Application for a minor material amendment to Planning Permission 21/03347/FUL (as already amended by 22/02041/S73).

Proposal: Demolition of existing dwelling and outbuildings. Erection of a replacement dwelling and outbuilding together with associated works and landscaping.

At: East Lodge The Green Kingham Chipping Norton

Project Address	East Lodge, The Green, Kingham, OX7 6YD		
Project Description	Proposed Dwelling		
Drawing Title	Proposed Elevations 2		
Drawing No.	2662-1121	Rev.	I

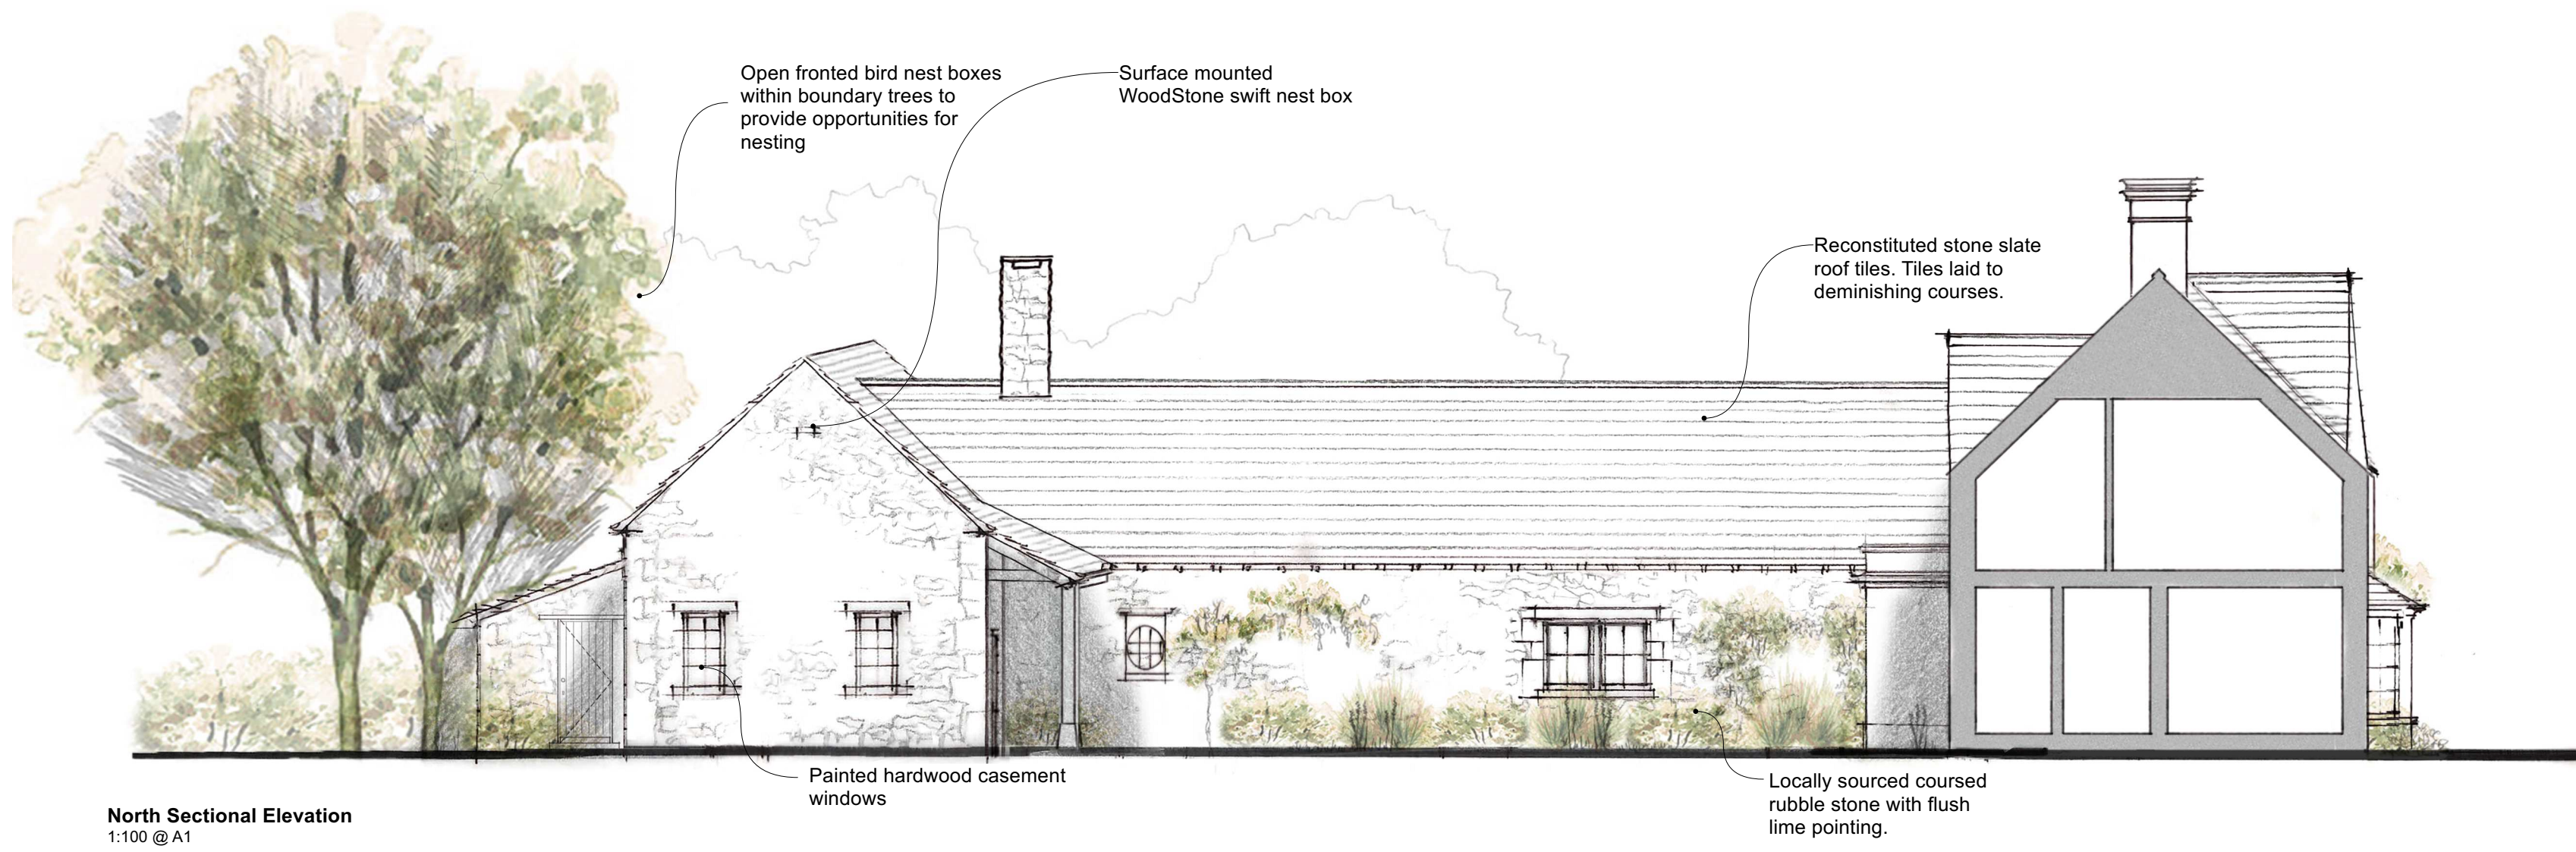
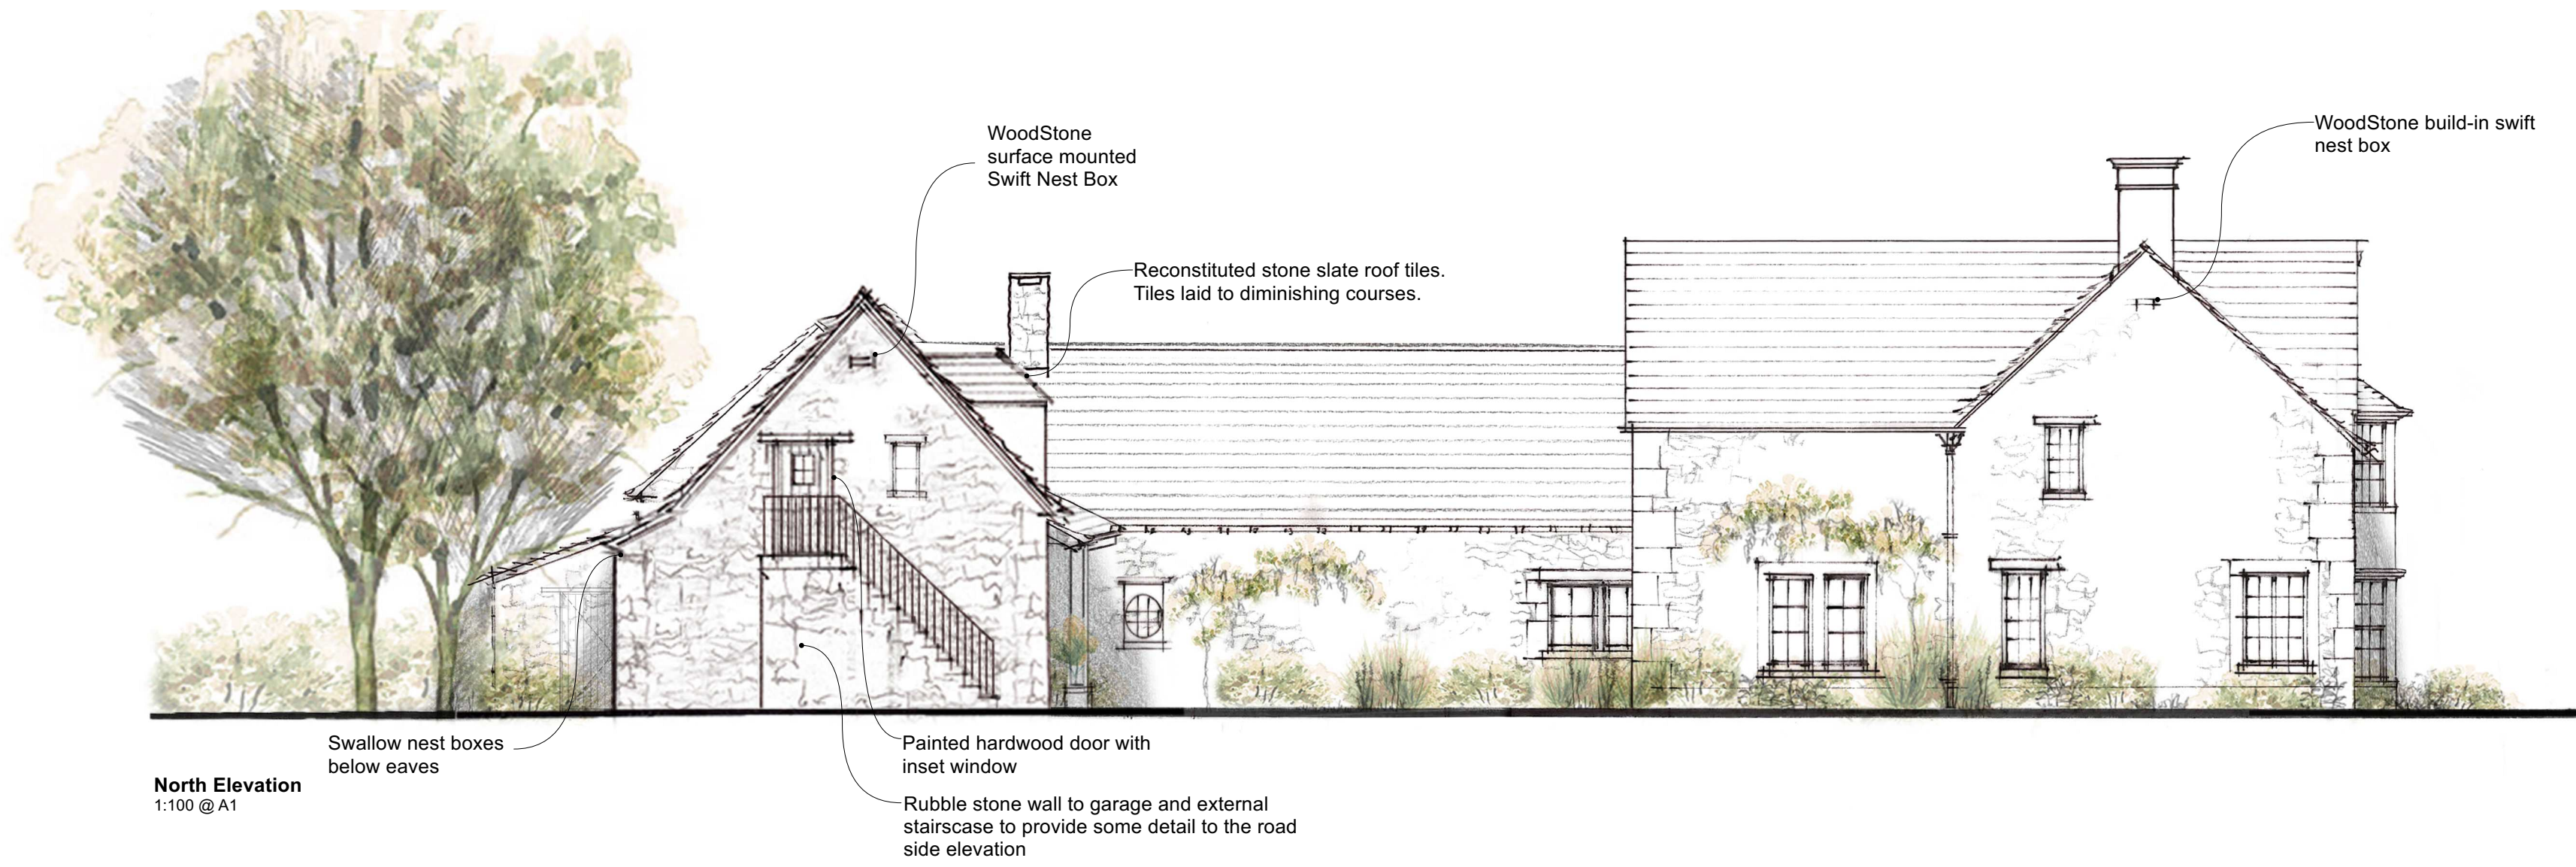
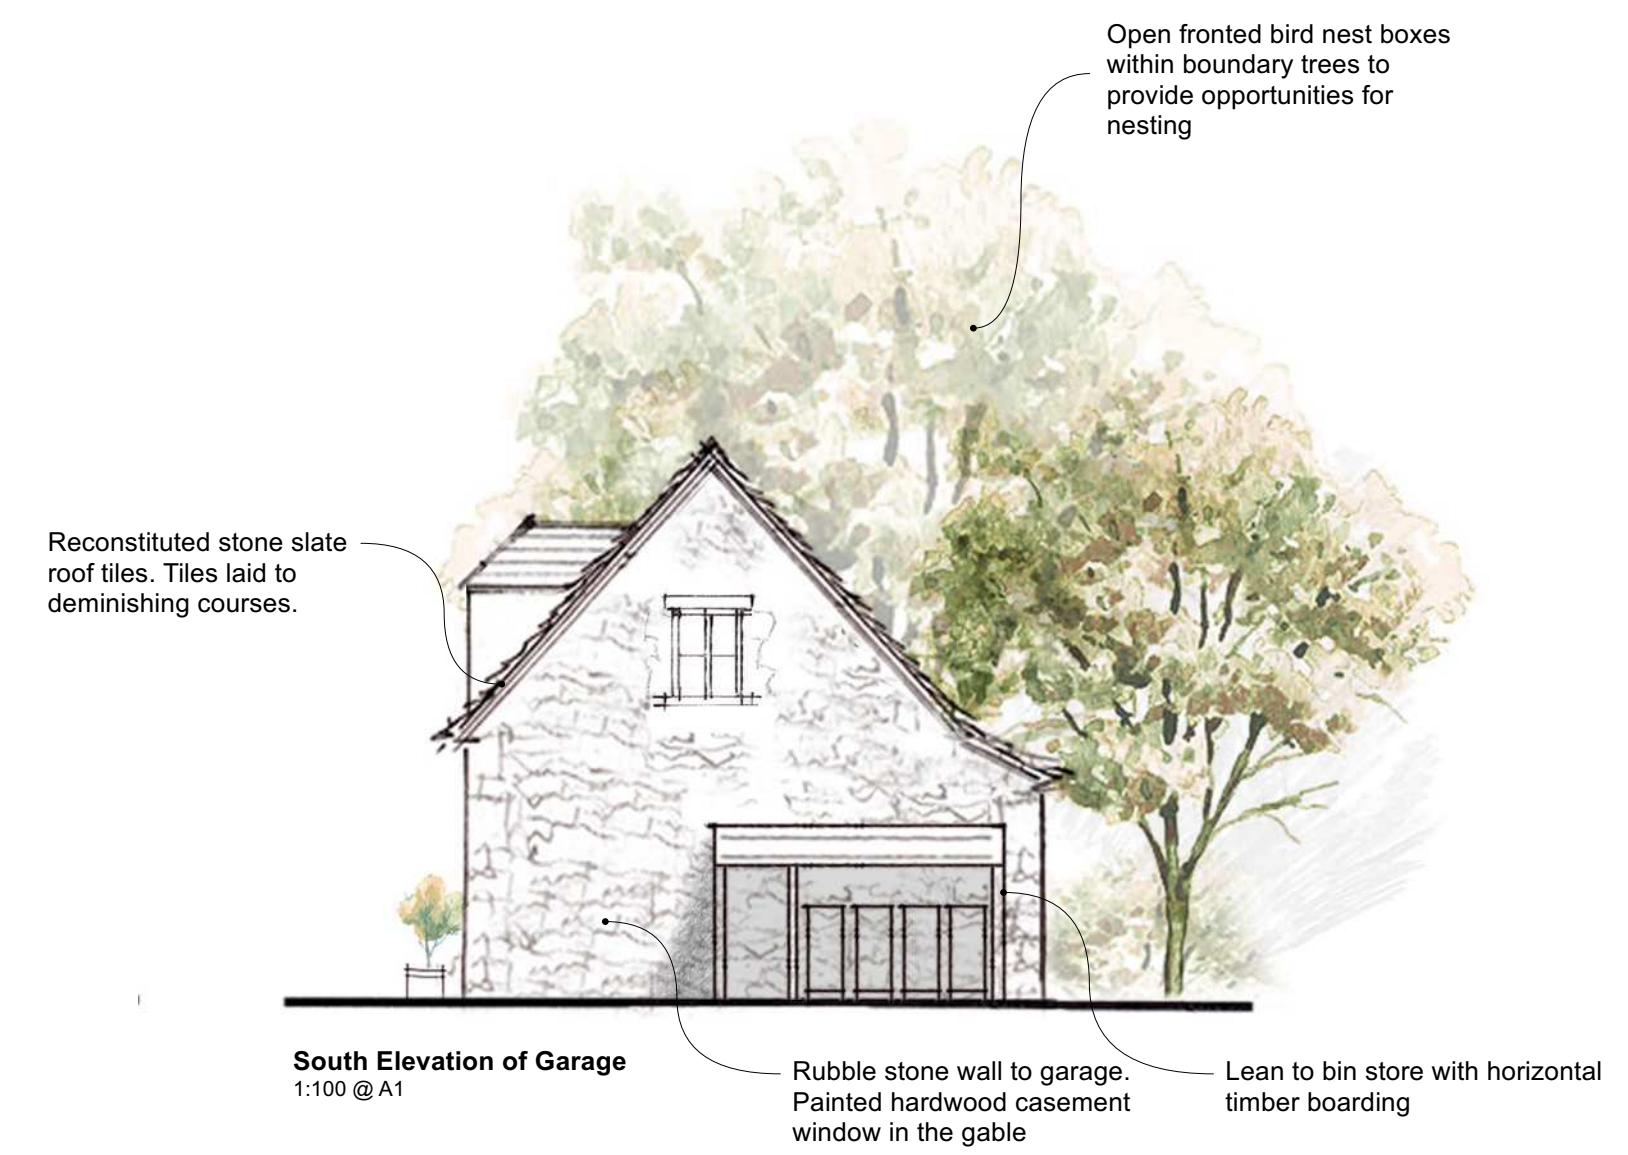
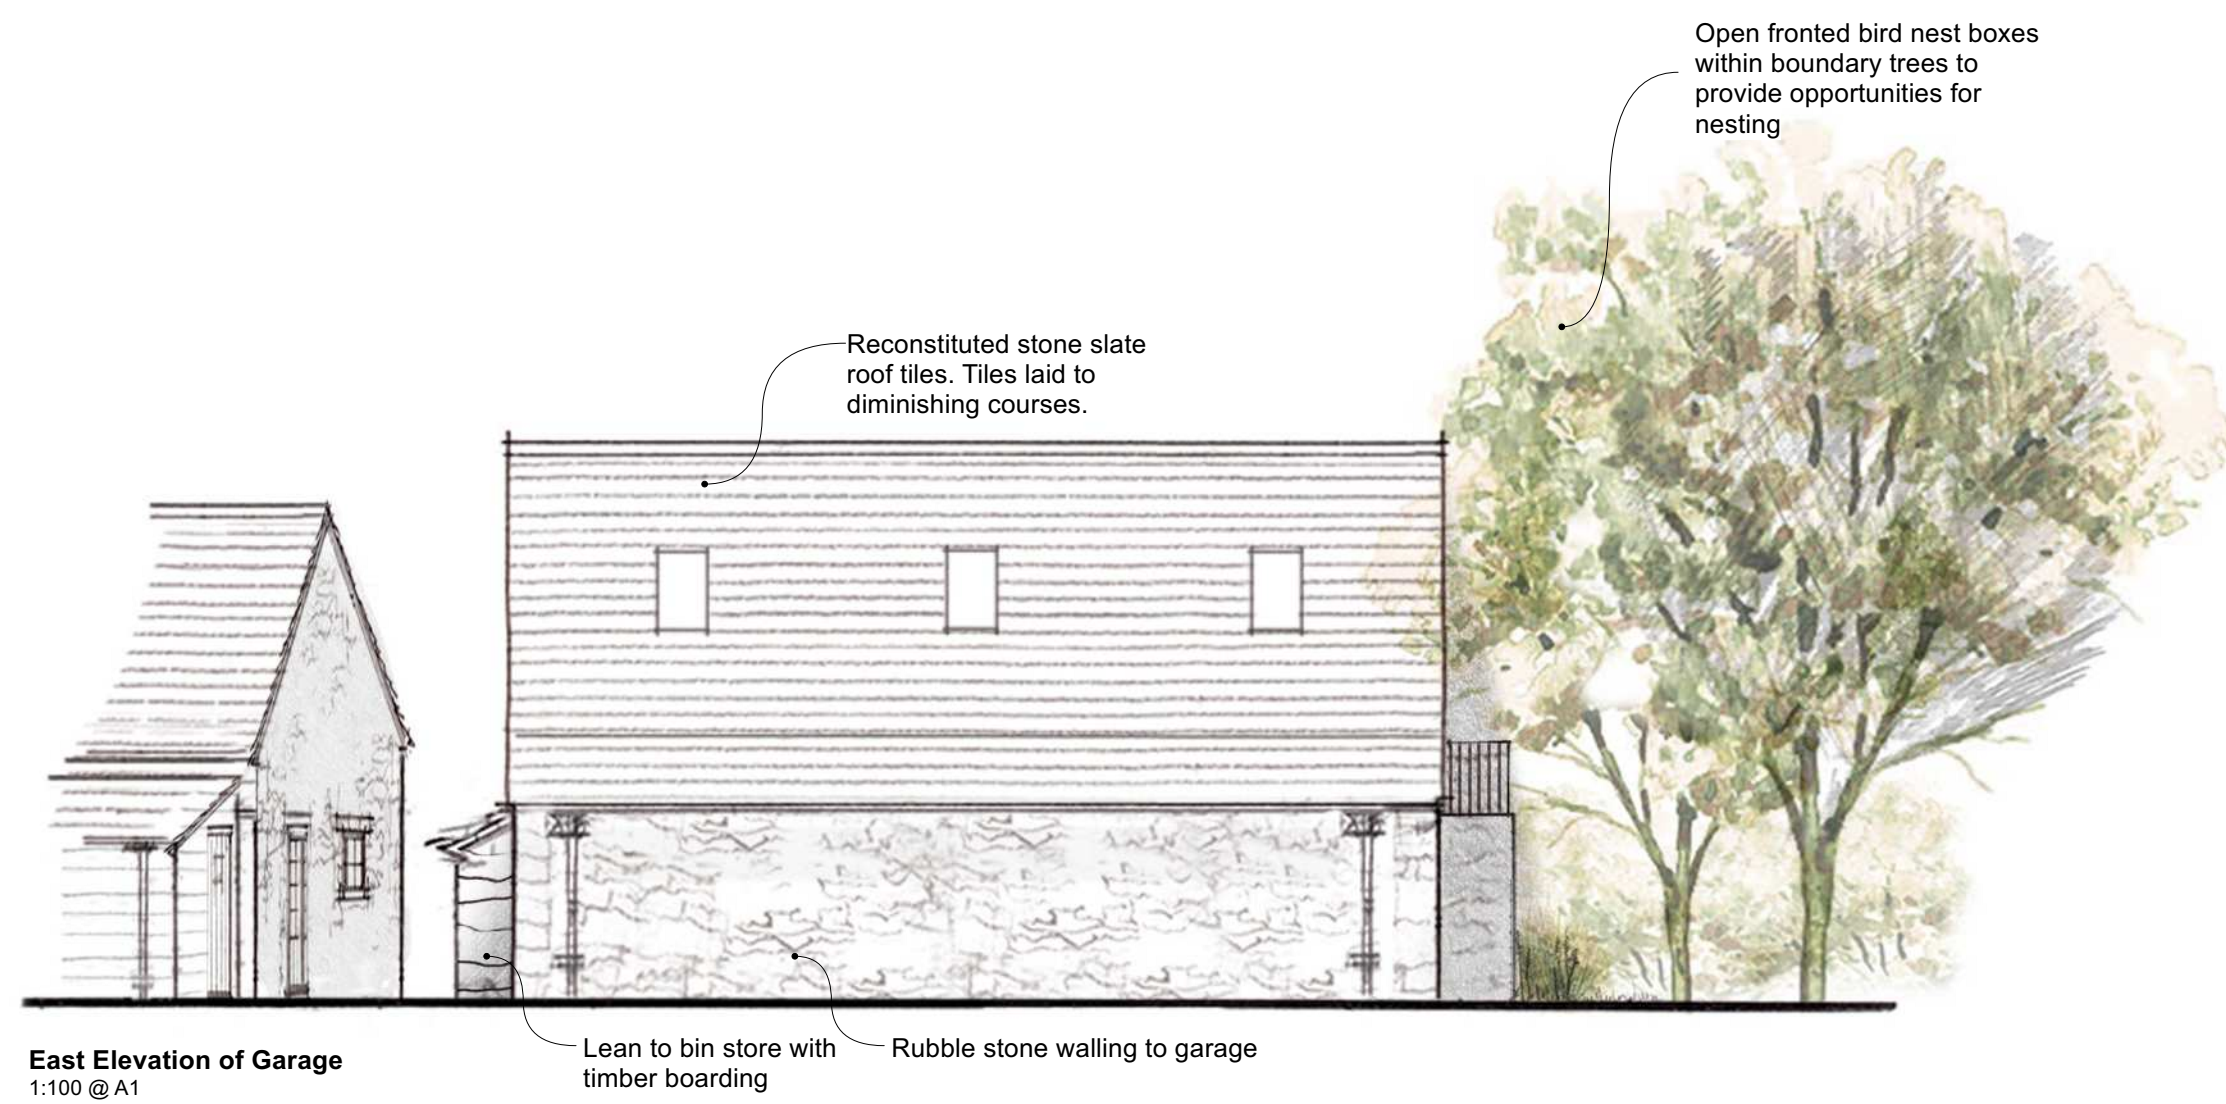
This would replace revision E. It shows the proposed lean to bin store, revised roof materials for the garage, extended eastern wing and includes details of the ecology mitigation for conditions 7 and 11
